July 5, 2018

**PROJECT:** 44395.1.1 (U-5824) Forsyth County  
Widen NC 66 (Old Hollow Rd) in Walkertown from Harley Dr. to US 158

**SUBJECT:** Final Design Field Inspection

**LOCATION: NC 66 (OLD HOLLOW ROAD) WIDENING  
FROM HARLEY DRIVE TO US 158 IN WALKERTOWN**  
**TYPE OF WORK: GRADING, DRAINAGE, PAVING, SIGNALS, AND RETAINING WALLS**

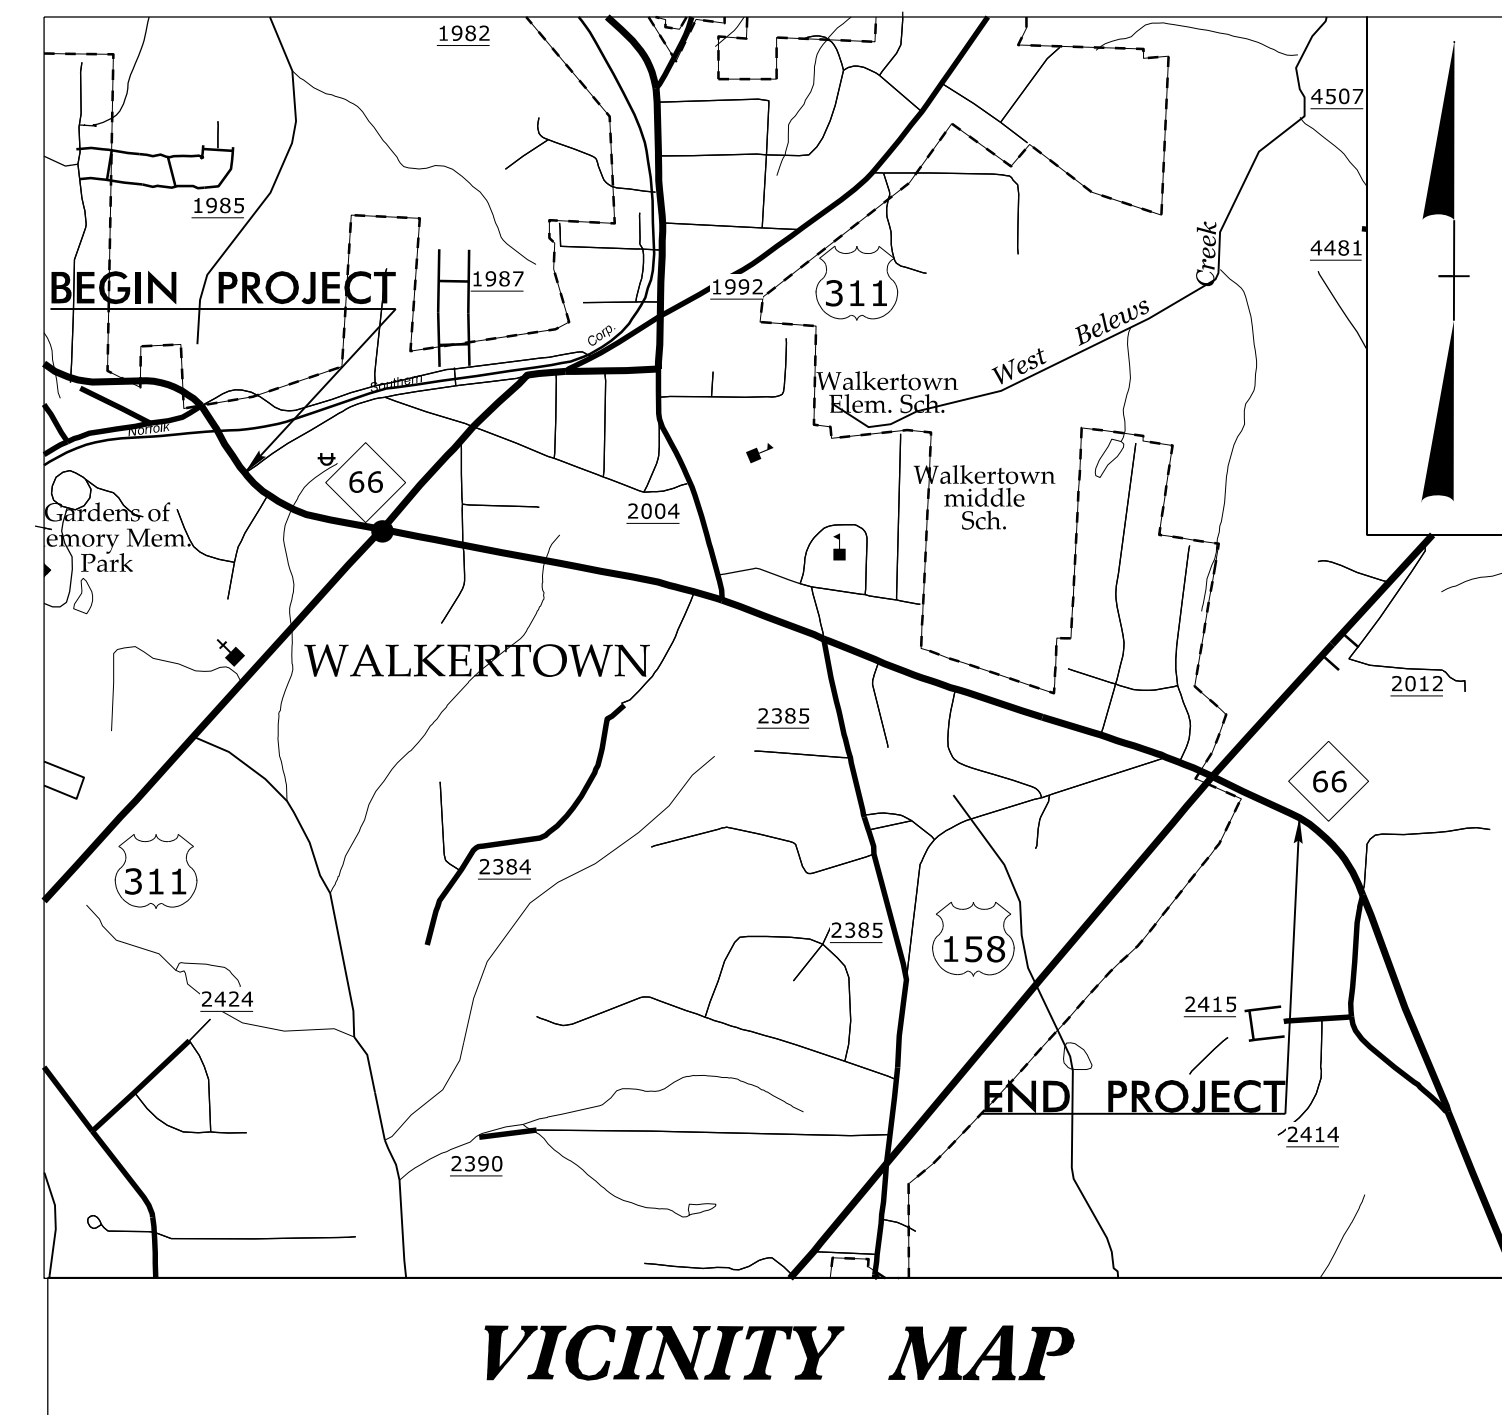
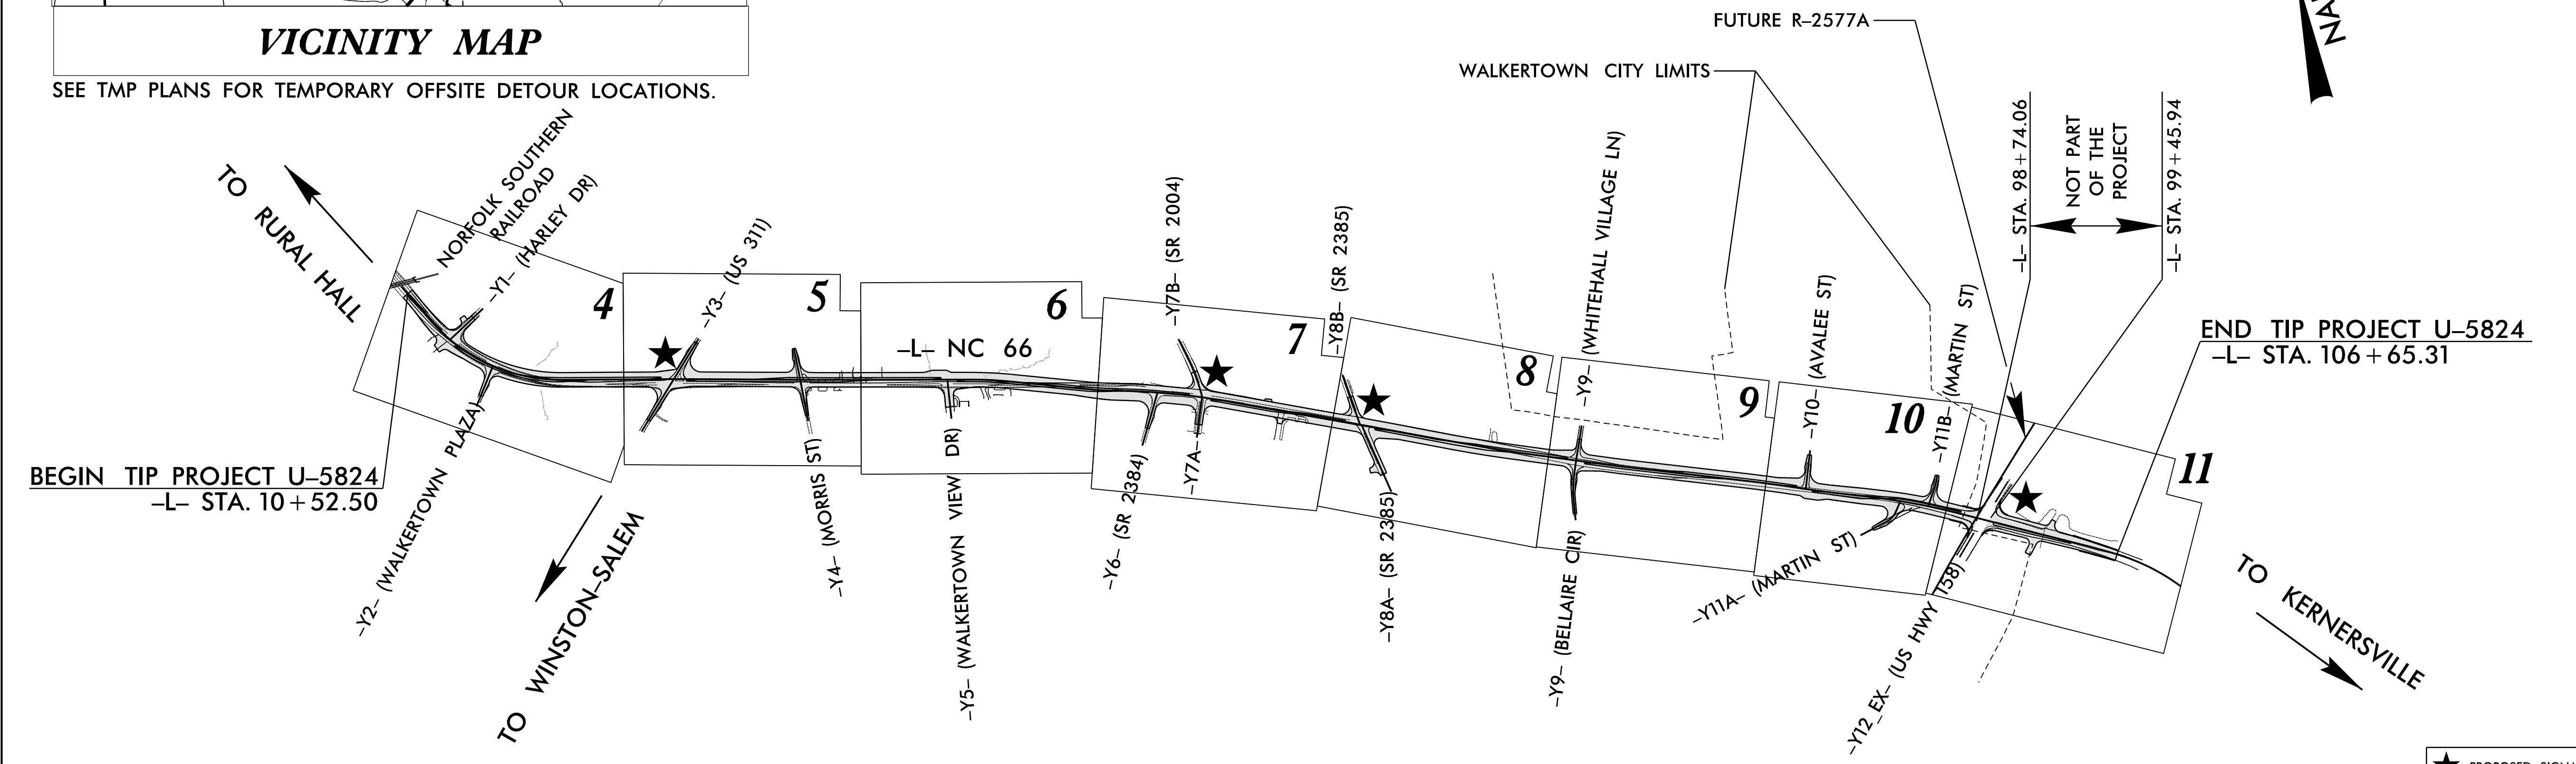
- C & G Method III
- ROW let date February 22, 2020
- Let date February 15 ,2022
- ROW/ Utility project number
